## MEMORANDUM

**Subject:** Application ID: 2014-051

**Date:** 5/23/2014

**Comments Submitted by: Marge Schmuckal/Zoning on 5/23/2014**

Preliminary Site Plan

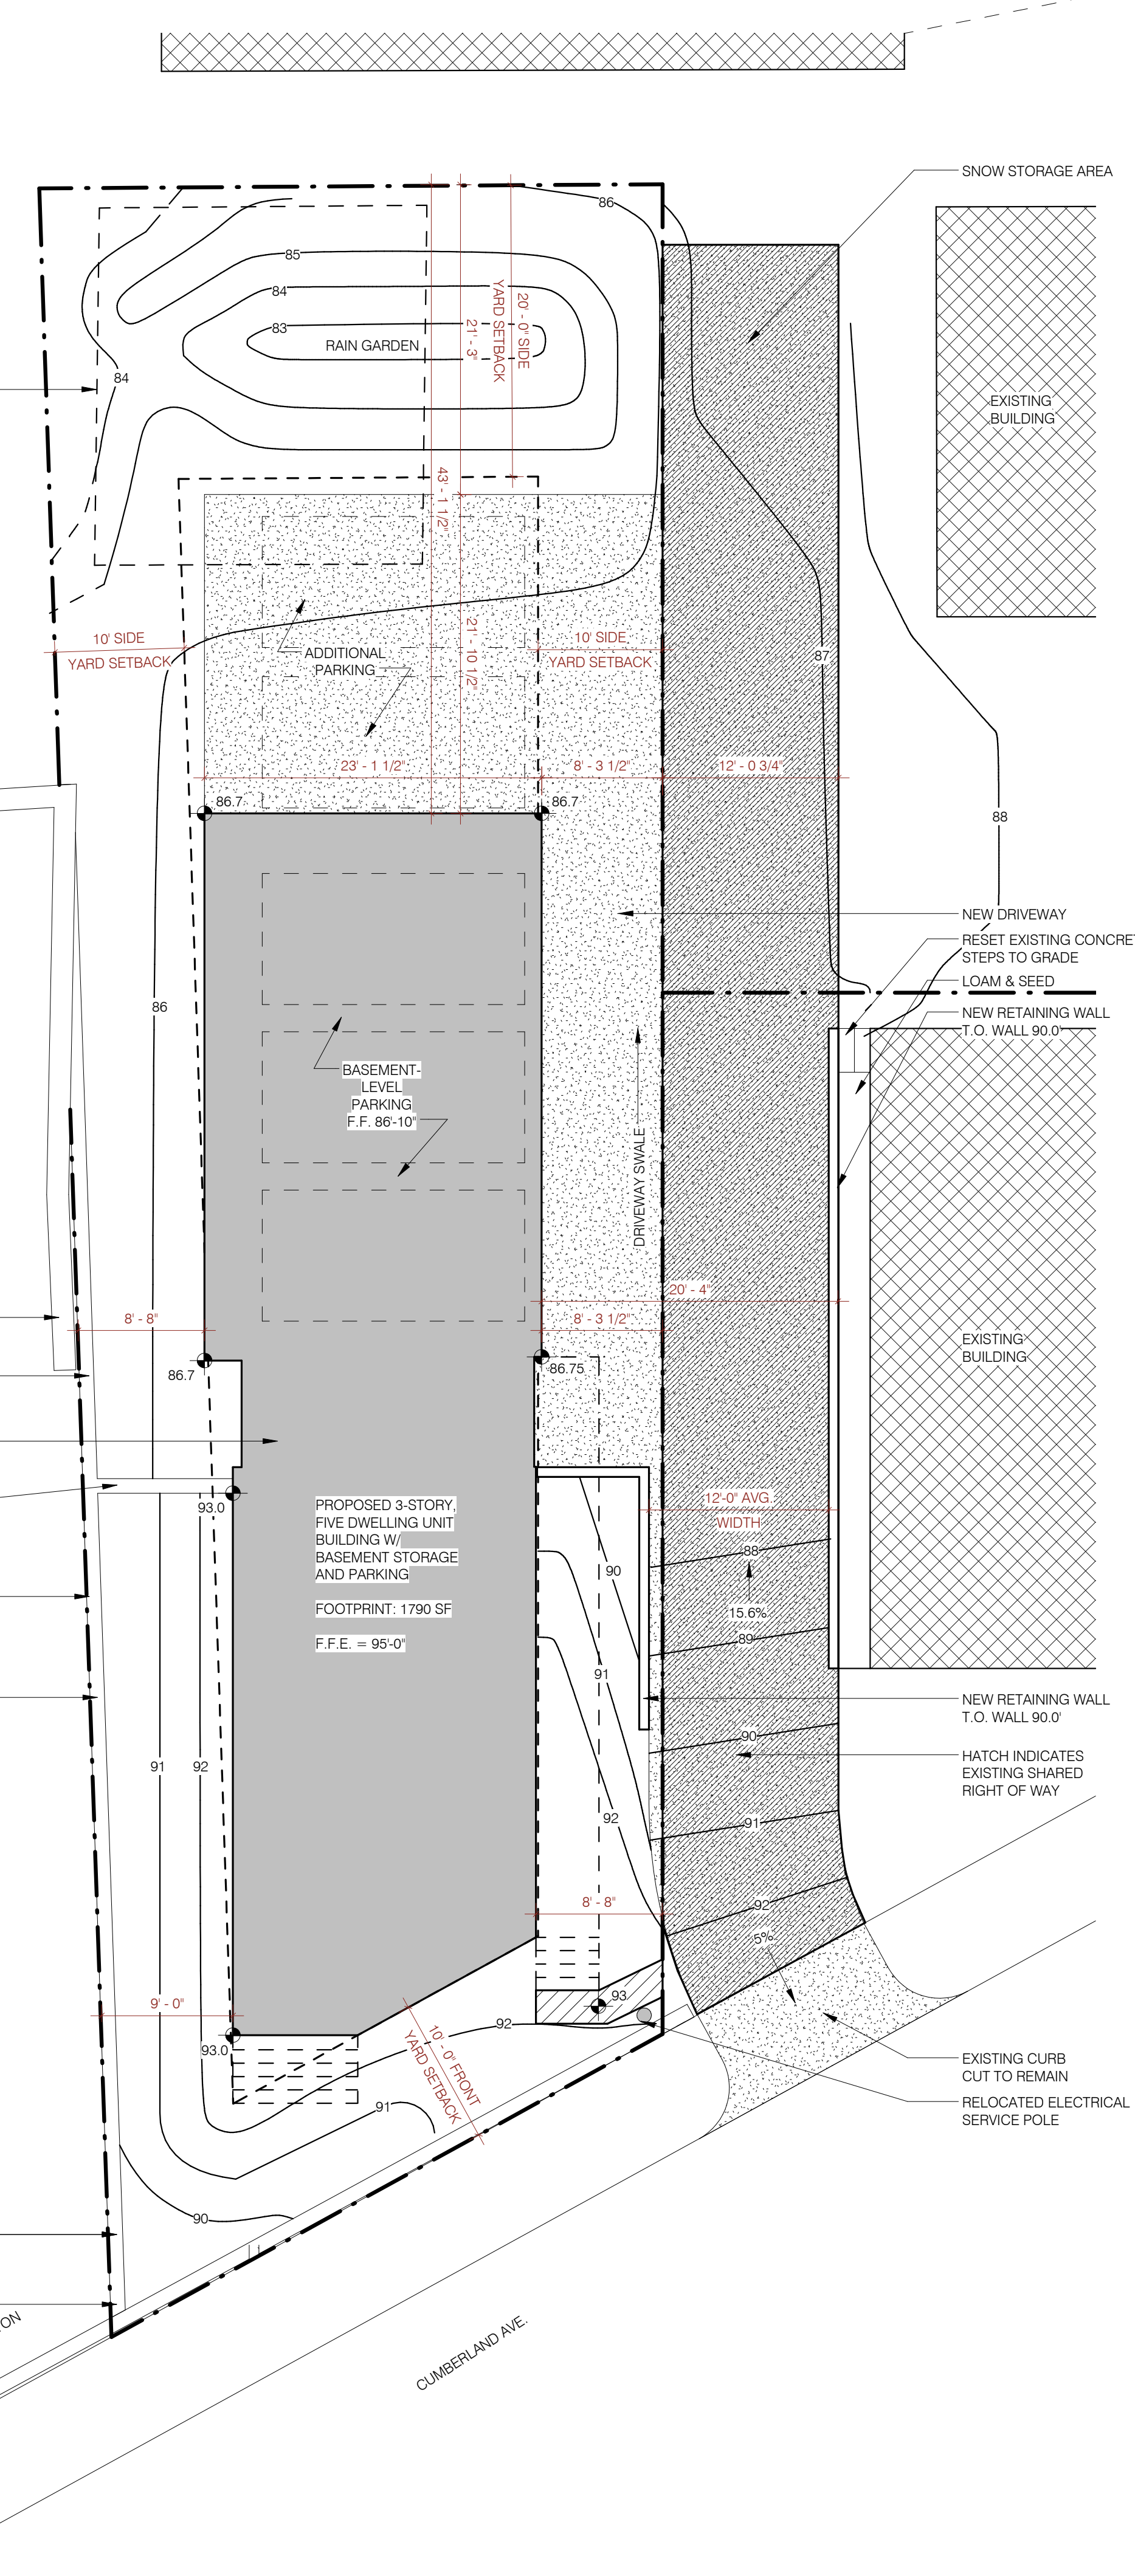
I have reviewed this project for a new 5 unit residential 3-story structure. My major concern after this review is the required 10' side setback for the building. Both sides are not meeting the required minimum 10' setback. I am uncertain why the applicant is showing that there is less than the required 10' side yard setback when the document acknowledge the 10' required. All other R-6 dimensional requirements are being met.
